PLANNING & COMMUNITY DEVELOPMENT DEPARTMENT  
Land Use Review Division

RE: **Tutt Boulevard at Cottonwood Creek Plat – Initial Review Comments**  
File: **AR FP 19-00553**

TUTT BOULEVARD AT COTTONWOOD CREEK
 DRAWN BY: JLB CHECKED BY: JLB DATE: 07/10/19
 J.L. 17-023 SHEET 1 OF 2

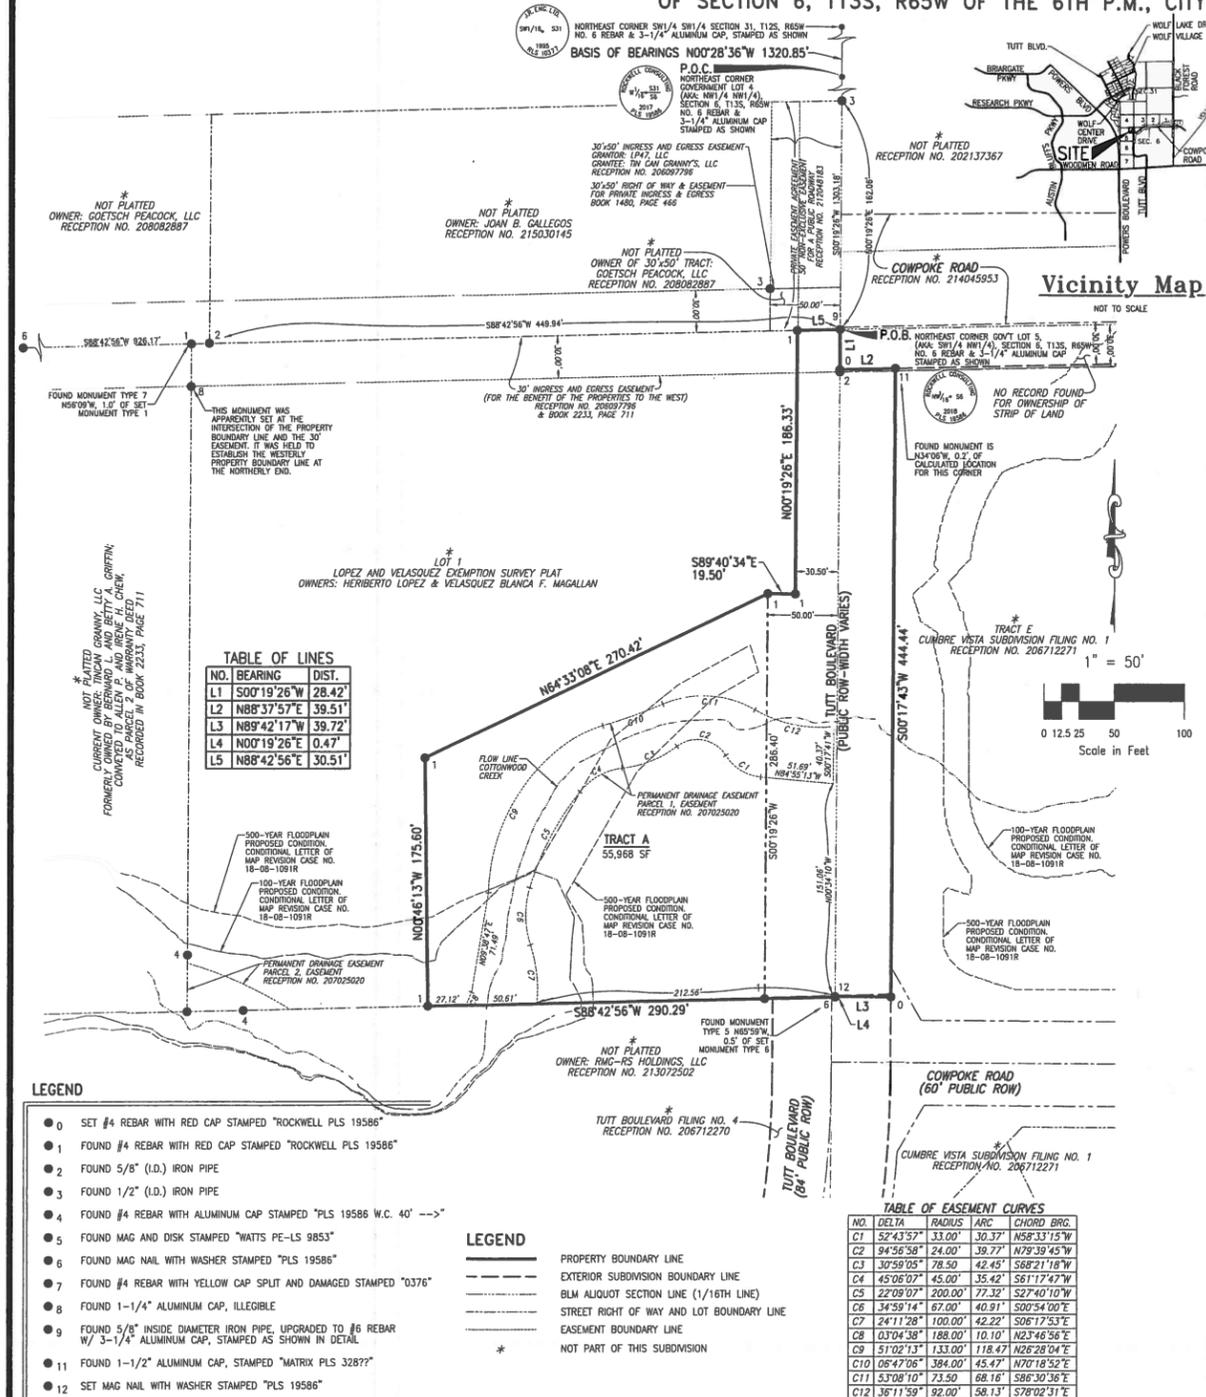
1. Please revise "know all men by these presents" to "that the City of Colorado Springs, a Home Rule City and Colorado Municipal Corporation, acting by and through John W. Suthers, Mayor, being the owner of the following described tract of land".
2. Please revise the "dedication" and "owner" as follows:  
Dedication:  
the undersigned owner has caused said tract of land to be platted into a tract and public street as shown on this plat. Said street is designated by the City of Colorado Springs for public use. This tract of land as platted herein shall be known as "Tutt Boulevard at Cottonwood Creek" in the City of Colorado Springs, County of El Paso, State of Colorado.

3. Please complete the City File No. AR FP 19-00553.
4. Please add a plat note in regards to ownership, use and maintenance of tract A.
5. Note 4, as noted is for the United States Air Force Academy, does it apply? Should the language be revised to the language used for the Colorado Springs Airport? Please review and revise as appropriate.

1. Add a Tract A note for its description/use; and please include Public Trail Access as one use, along with any other uses.

1. If an address is needed for Tract A, the applicant should contact Enumerations to request one to be placed on the mylar.
2. The plat shows the street name of Cowpoke Rd. at the end of the Tutt Blvd extension. Cowpoke Rd. has been re-routed and the letter of intent states that the bridge which services this section will be removed. There has been some discussion in the past regarding renaming this section of Cowpoke as Old Cowpoke and performing address changes for those properties currently addressed along the old section of Cowpoke Rd. What is the status of this street name change?
3. Standard final plat comments apply.

1. Ownership Statement ("Know all Men....") – Please correct: "That The City of Colorado Springs, Colorado, a home rule city and Colorado municipal corporation, on behalf of its Public Works Department, acting by and through John W. Suthers, Mayor, being the owner.....".
2. Dedication Statement: "...has caused said tract of land to be platted into Public Right-Of-Way and a Tract (remove Lots and Easements). Then remove everything after that up until, "This tract of land shall be known as.....".
3. City signature block: please correct the name of the Mayor – John W. Suthers (not John Sunderland). Also include his middle initial.
4. Please remove the notary block for the Mayor and replace it with an Attest by the City Clerk.

5. Both TSN's show their northerly property line being exactly the same and not being staggered. Is the most northerly 28.42' of parcel 5306200004 being left off of this plat (See your L2 & L5)?
6. City Approvals: Please change "City Engineer" to "Director of Public Works".

The plat shows and calls out CLOMR line work which is not correct and should be removed. Current effective FEMA approved base flood elevation data and 100-year floodplain boundaries should be shown.  
The Plat NOTE should be corrected to reflect those changes.
